# Comments for Planning Application 21/00322/FUL

Application Number: 21/00322/FUL

Address: 24 Rosamund Road Oxford OX2 8NU

Proposal: Alterations to roof to form hip to gable, formation of 1no. dormer to rear roofslope, insertion of 1no. rooflight and 3no. additional solar panels to front roofslope. Demolition of existing rear extension and erection of a single storey rear extension. Insertion of 1no. window to front elevation, removal of 1no. window and door to side elevation, alterations to fenestration and painting of existing render. Demolition of 2no. existing outbuildings and erection of a rear garden outbuilding.

SURVEY AS EXISTING  
Date: 09DEC20  
Drawn: JCF  
Scale: 1:100  
A2 1:50

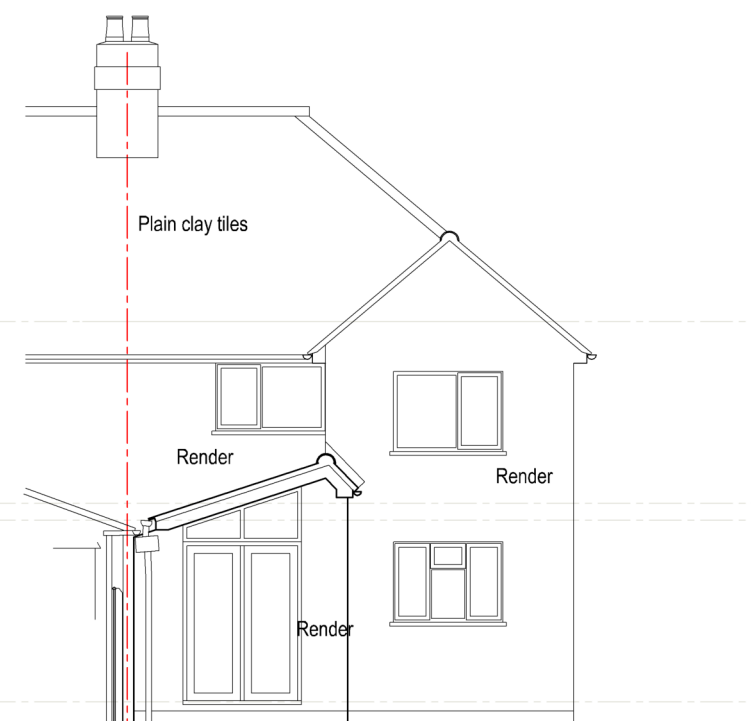
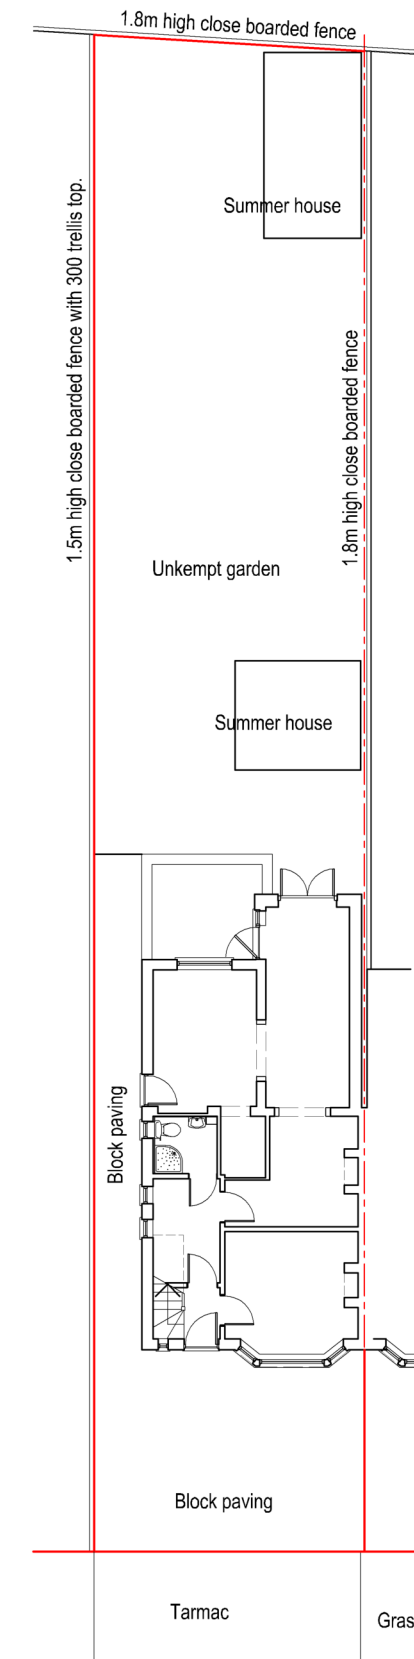
More worryingly, the sketch also proposes a new first-floor window in the front elevation. Looking to the sketch of the existing building, the architect has removed (or, perhaps, simply did not notice) perhaps the most distinguishing features of the houses on Rosamund Road, and that is the diamond placed in the otherwise blank wall. In only one of the 76 houses in Rosamund Road has this feature not been preserved. The architect's drawing of the existing building mysteriously fails to show this whimsical embellishment that is obvious at first glance. Instead, it has been replaced by the word, 'Render'.

BLOCK PLAN  
Scale 1:200

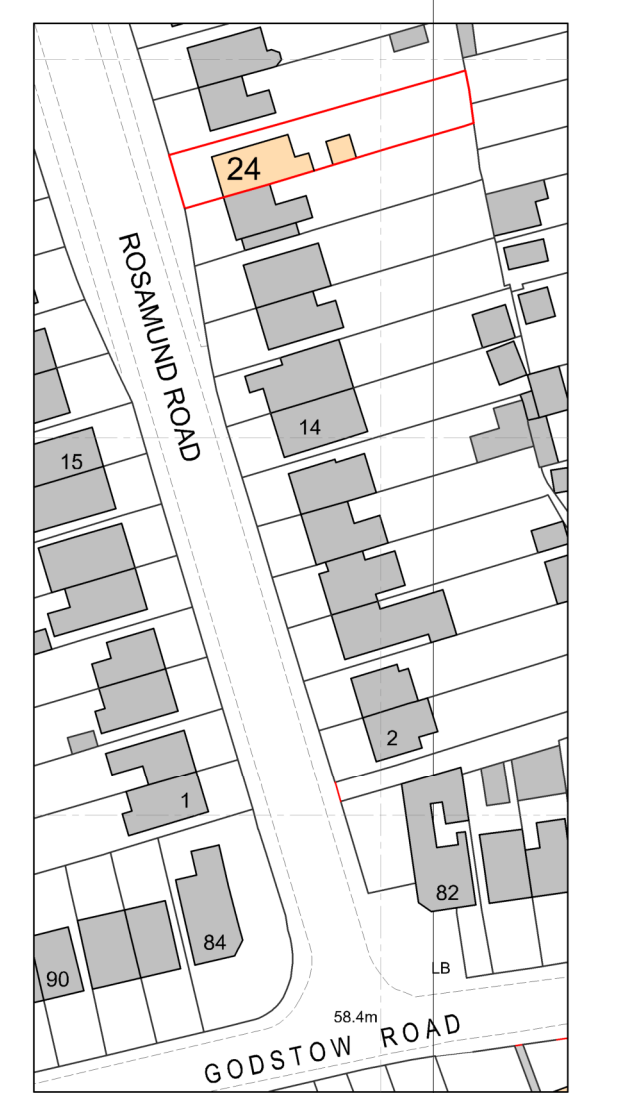
This is especially important in the present application because of the way the building sits on the site. The application shows a sketch of Any Semi in Any Town. A generous application would give back the tree, remove some tarmac and offer the community some grass.
